Re: Objection to MP08_0244 MOD 1 Modification Request for Mixed Used Development at 23-37 Lindfield Avenue and 11 Havilah Lane, Lindfield

1 JUNE 21 -9AM
1:500

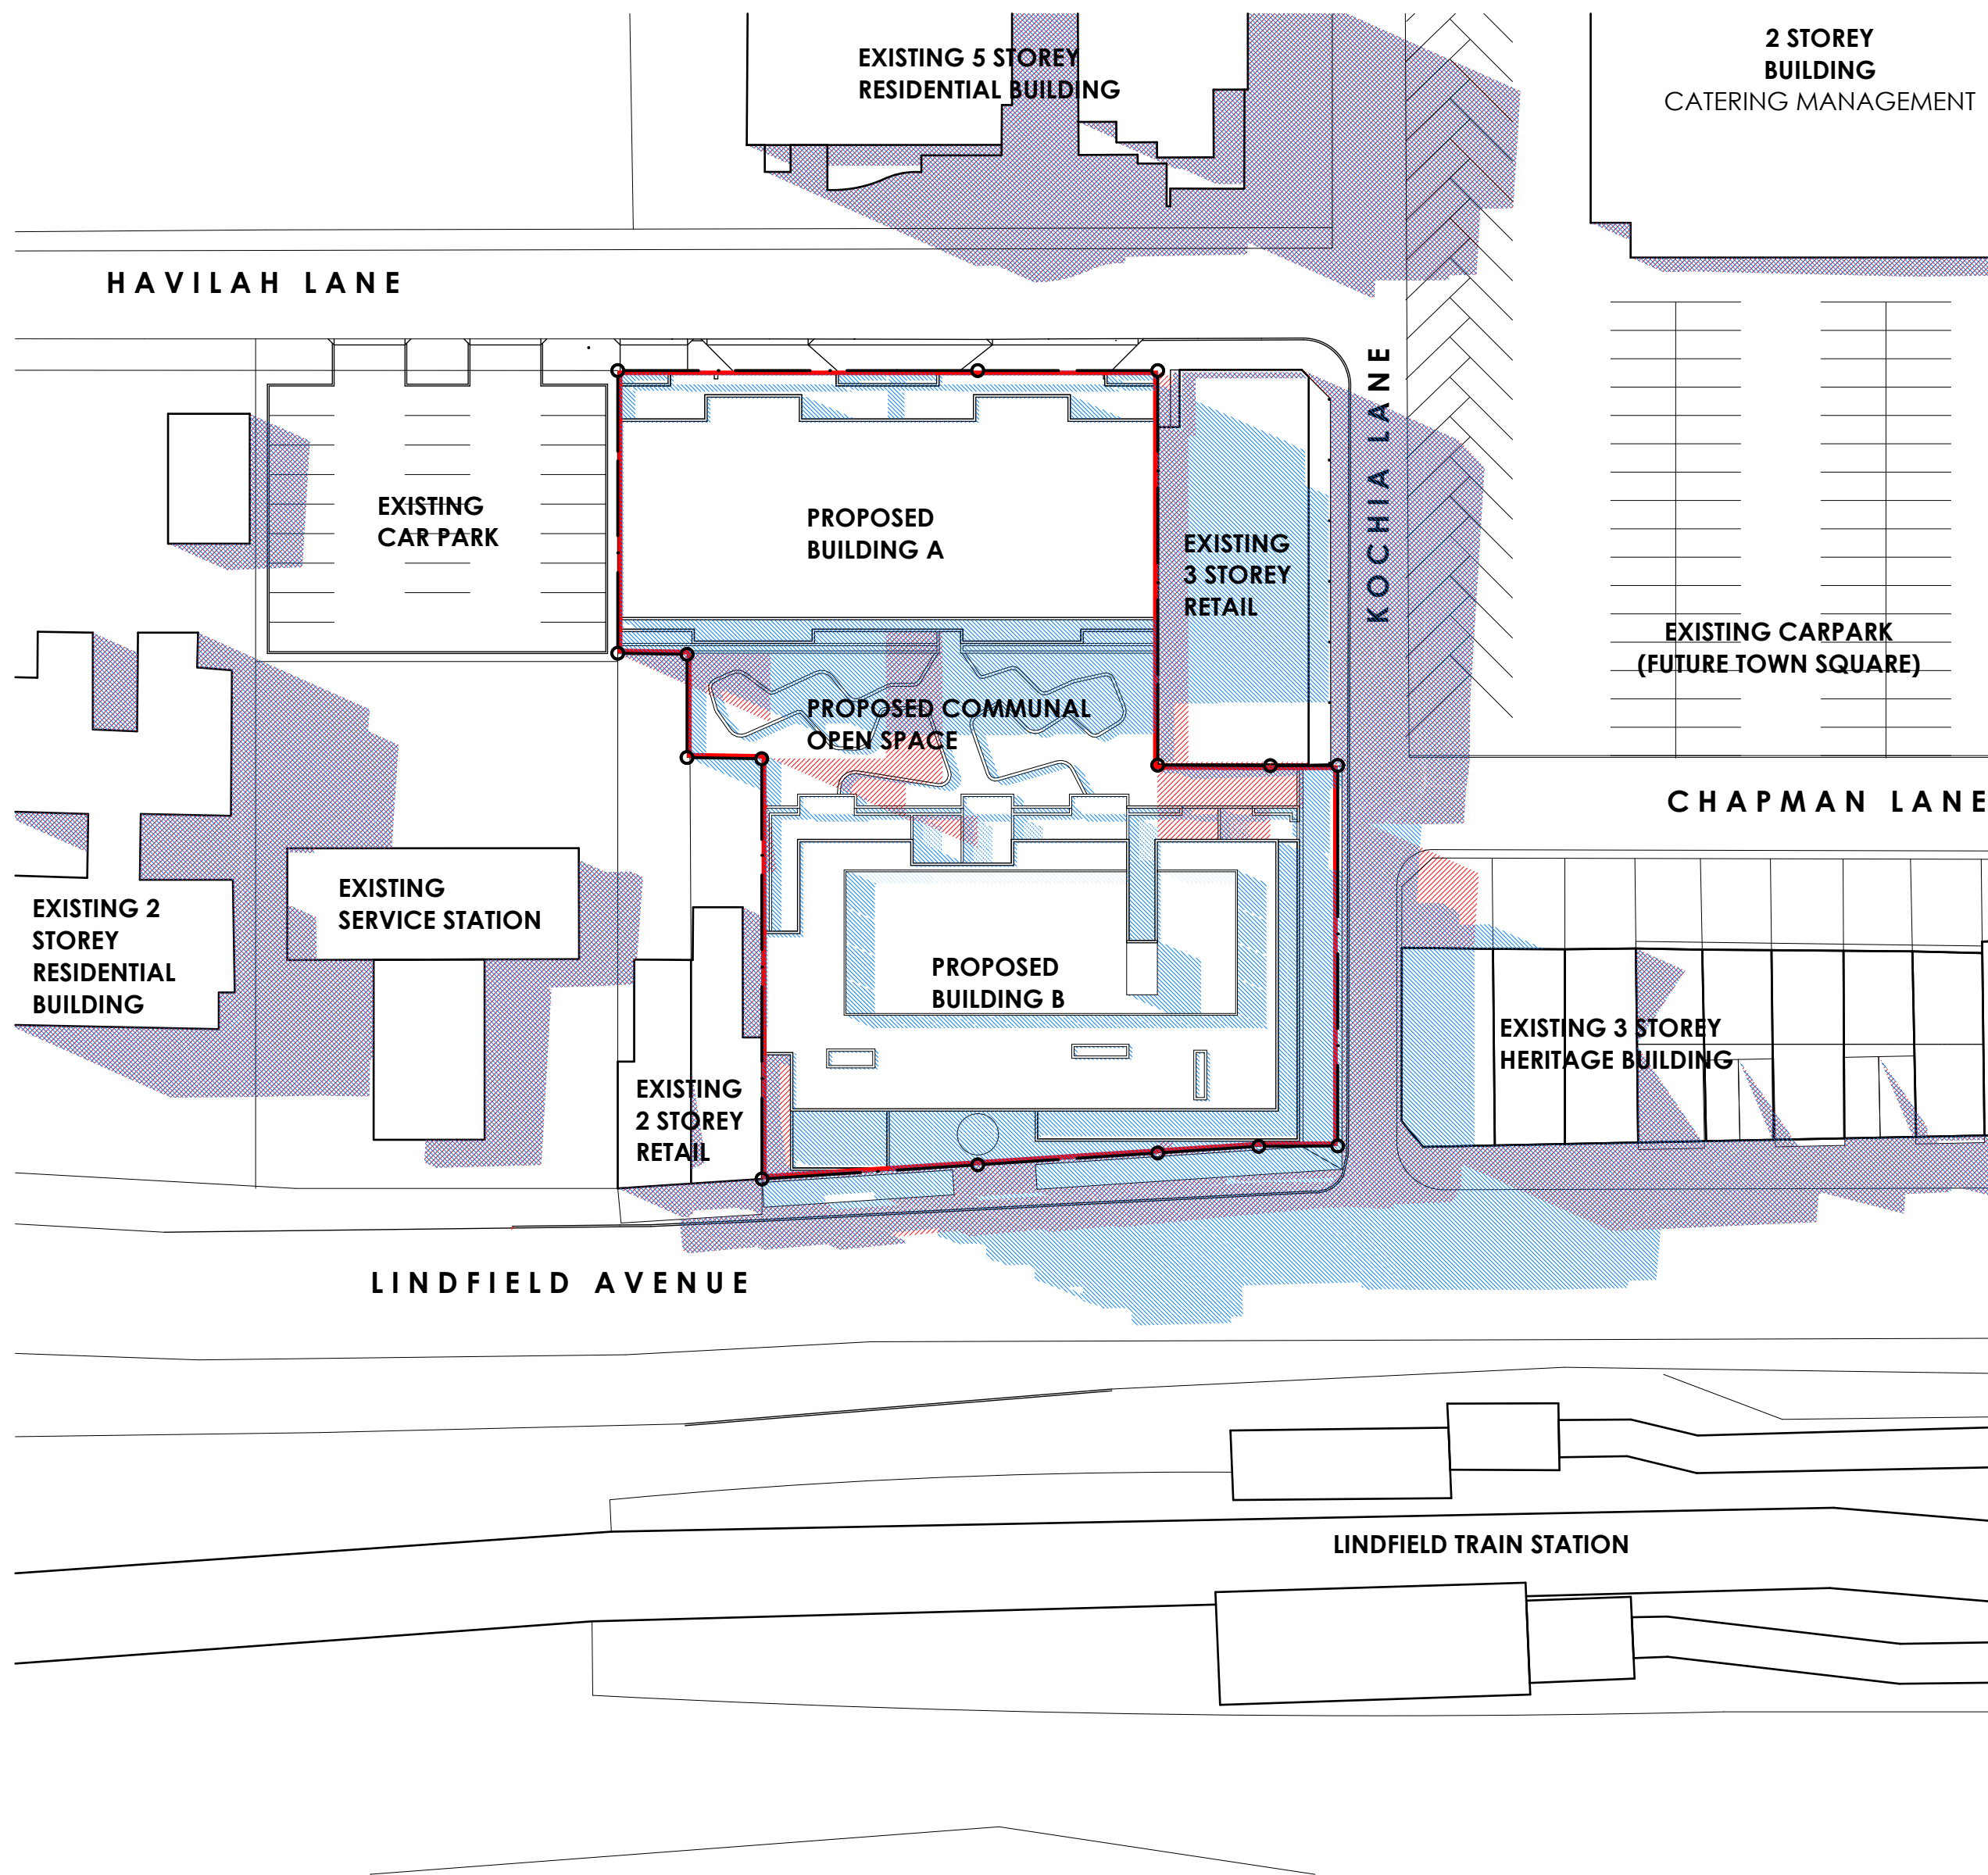
- The additional storeys create new adverse shadowing: a) for residents in the Havilah Lane apartments, particularly after 3pm b) for the popular outdoor café and central Lindfield hub area at 12 Tryon Road in afternoons, particularly in winter and c) for all commuters on the city bound Lindfield rail platform, instead of 50% of the year as approved, it will now be in shadow in the mornings 75% of the year
